November 19, 2021

RE: Village at Waterview North - EGP214

The Development Drainage Preliminary Drainage Report dated July 15, 2021 and supporting drainage documents has been reviewed by a CDOT Hydraulics Engineer and their comments are:

**WATERVIEW NORTH PRE-DEVELOPMENT  
 STORM WATER MANAGEMENT PLAN**

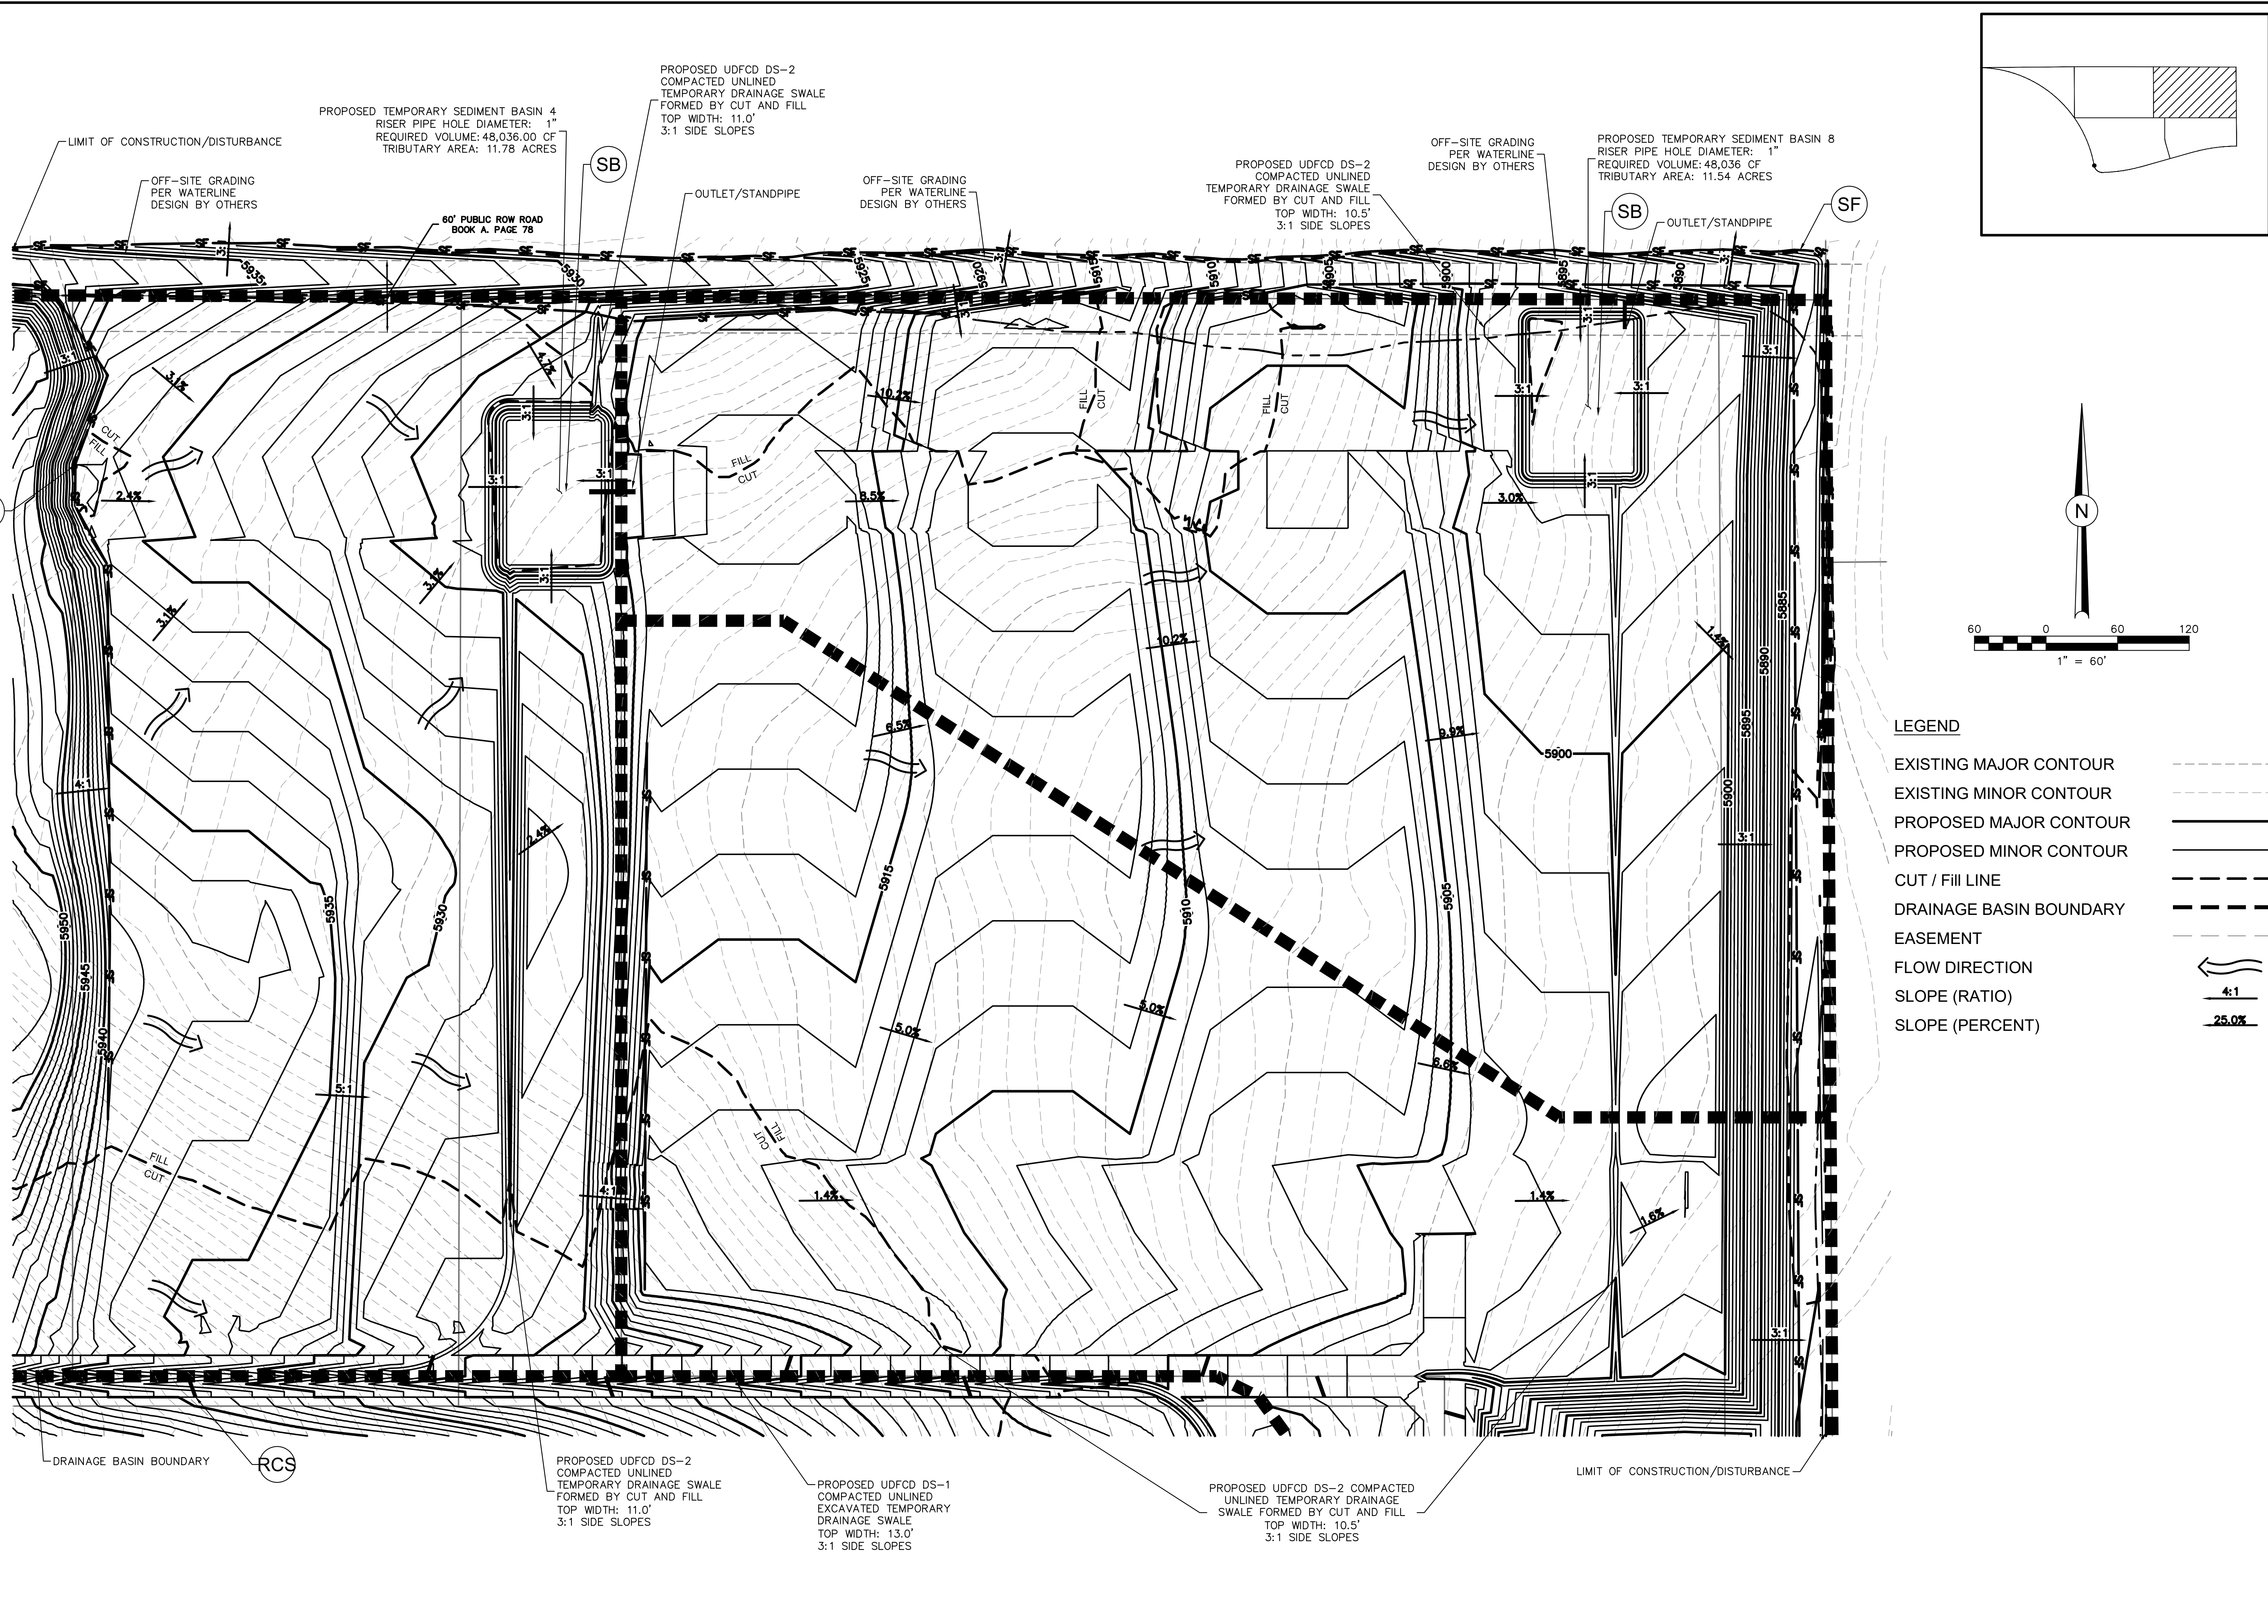
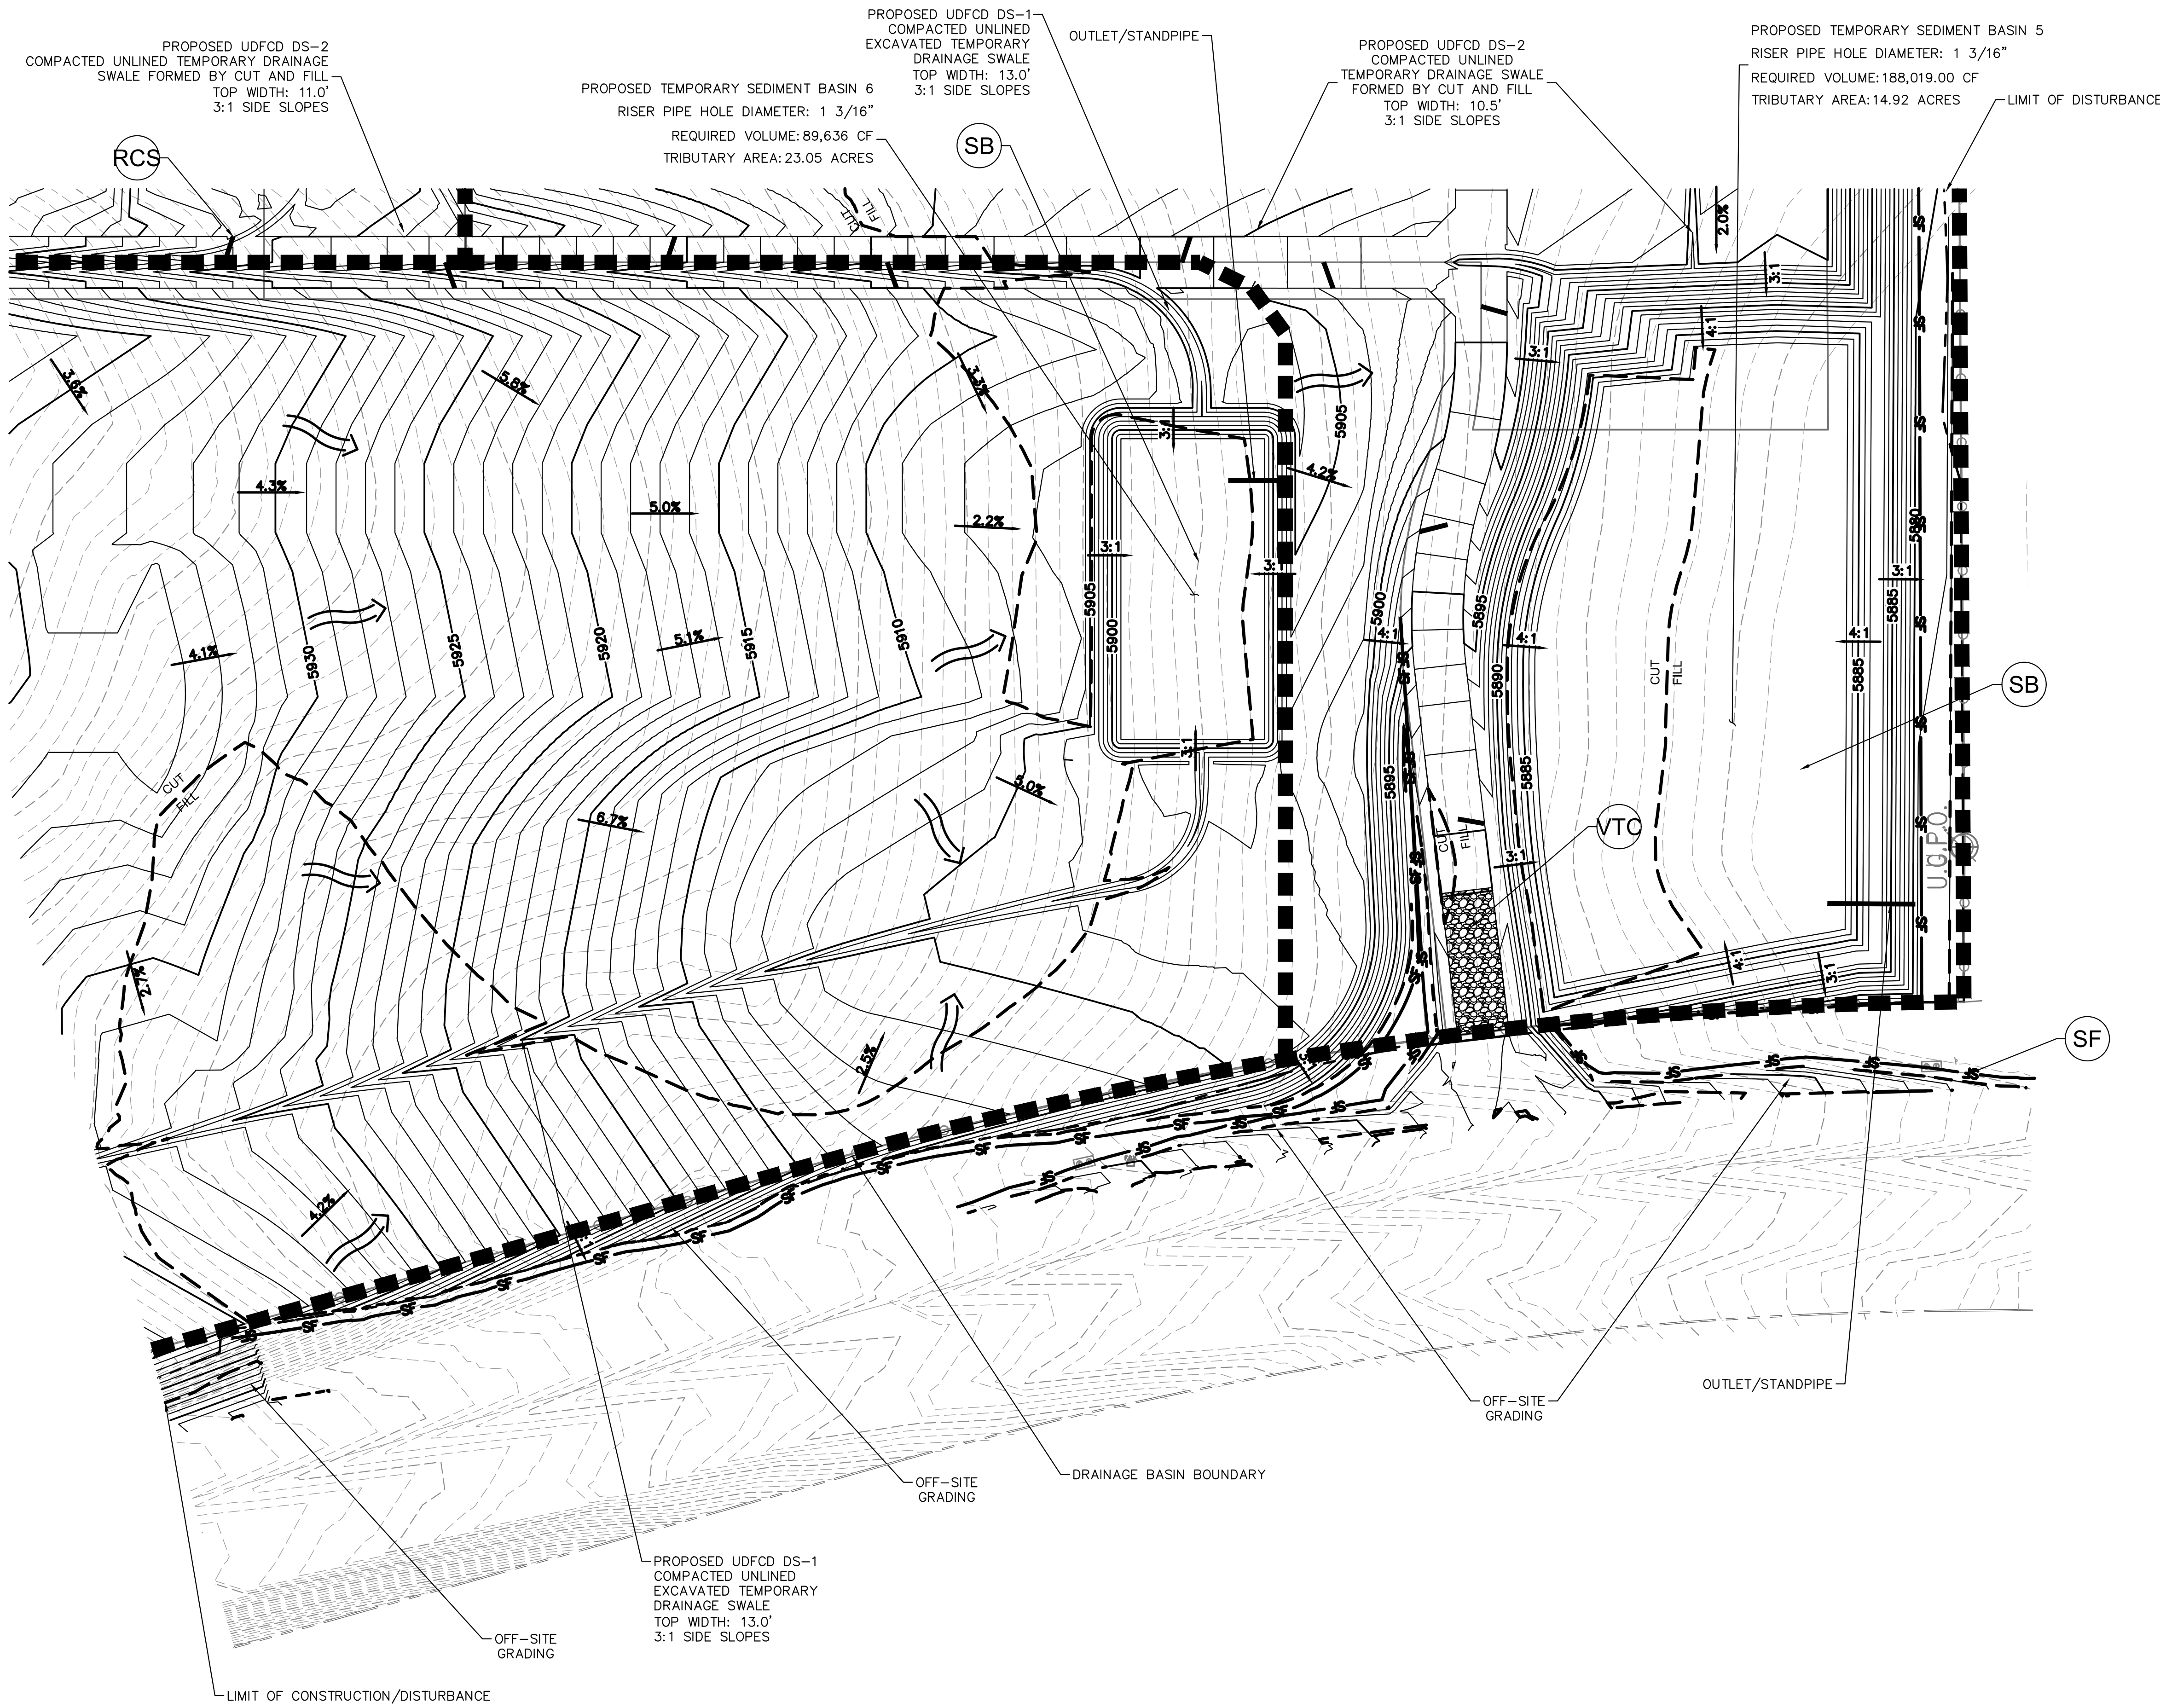
- On the grading and SWMP plans, the existing contours don't have elevations.
- There appears to be a pond/permanent sediment basin in the grading file in the NW corner, but it is not discussed in the drainage report.
